COLORADO
Division of Water Resources

August 1, 2022

RE: Latigo Filing 10 Deviation
Secs. 16 & 17, Twp. 12S, Rng. 64W, Sixth P.M.
Water Division 2, Water District 10
CDWR Assigned Referral No. 30411

Approximate location of interim infiltration pond

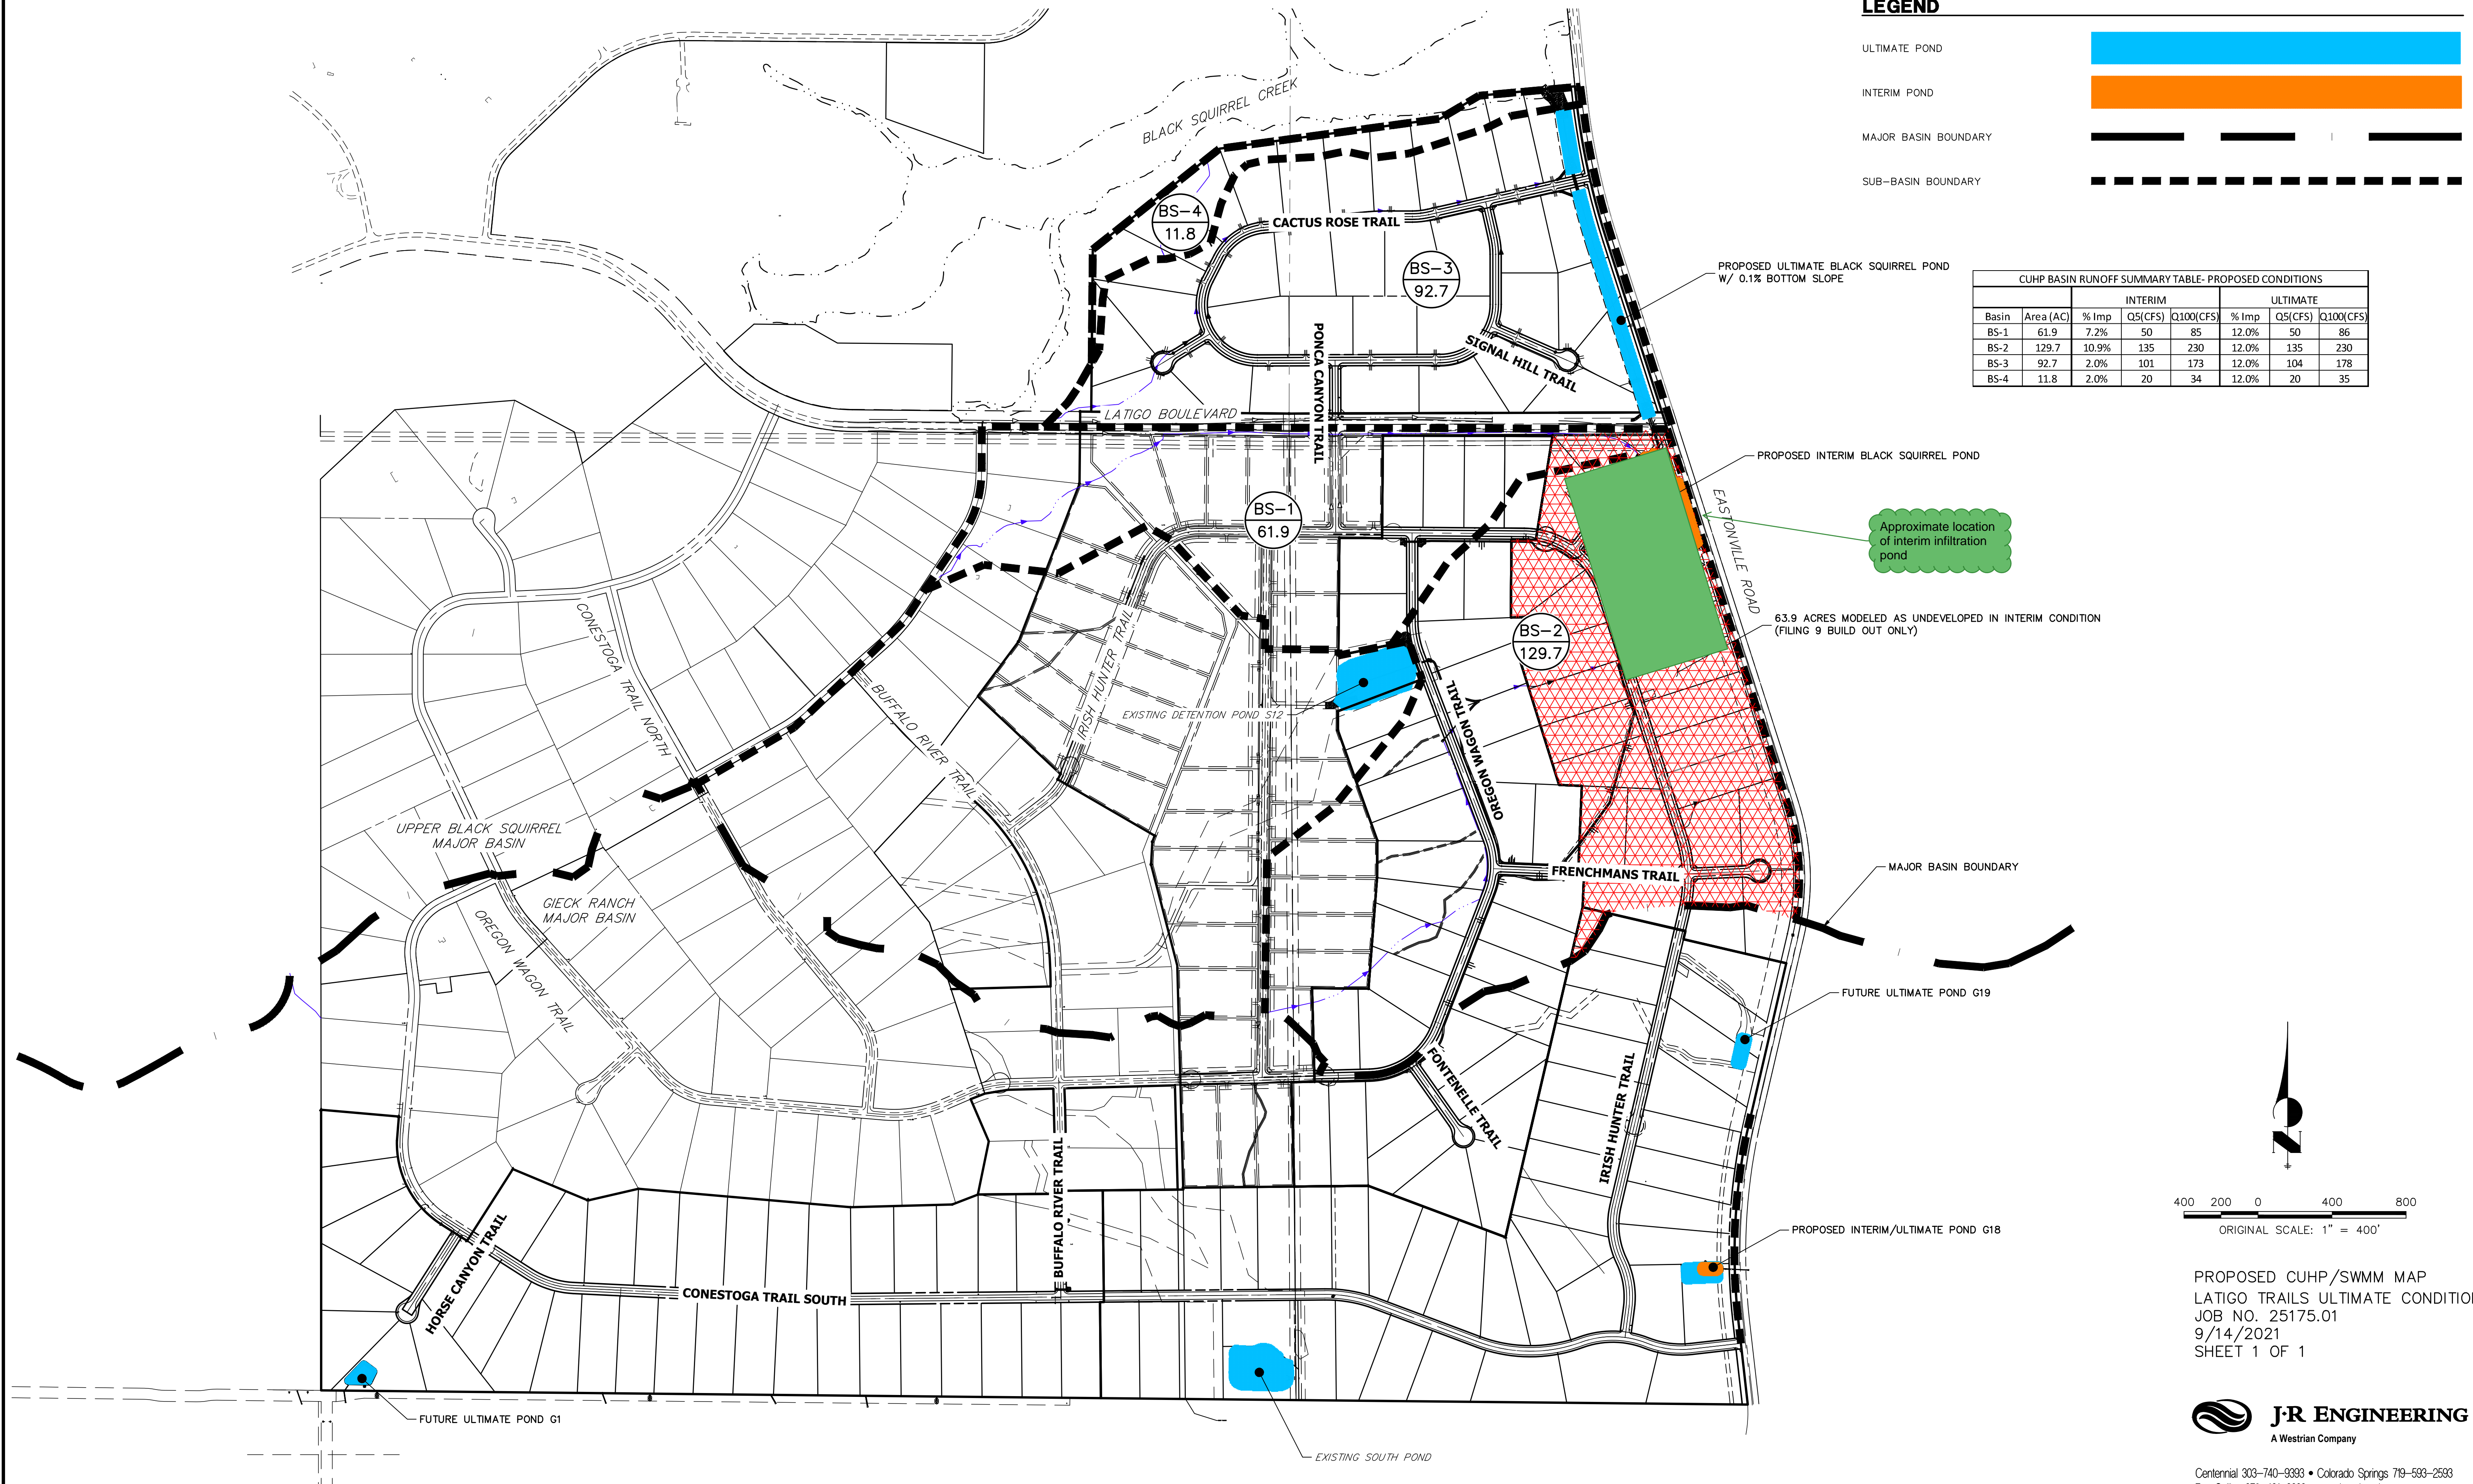
The Applicant is requesting a deviation for an existing stormwater detention structure to enable the structure to infiltrate all of the water captured during a storm event. Stormwater detention will be provided for Latigo Filings 10, 11 and 13. The pond will retain and allow to infiltrate the 100-year stormwater runoff volume, which is approximately 60 acre-feet.

The submittal indicates that an existing stormwater detention structure will be constructed for this project. The applicant should be aware that, unless the structure can meet the requirements of a “stormwater detention and infiltration facility” as defined in Designated Basin Rule 5.11, the structure may be subject to administration by this office. The Applicant should review Rule 5.11 to determine whether the structure meets the requirements of the Rule and ensure any notification requirement is met.
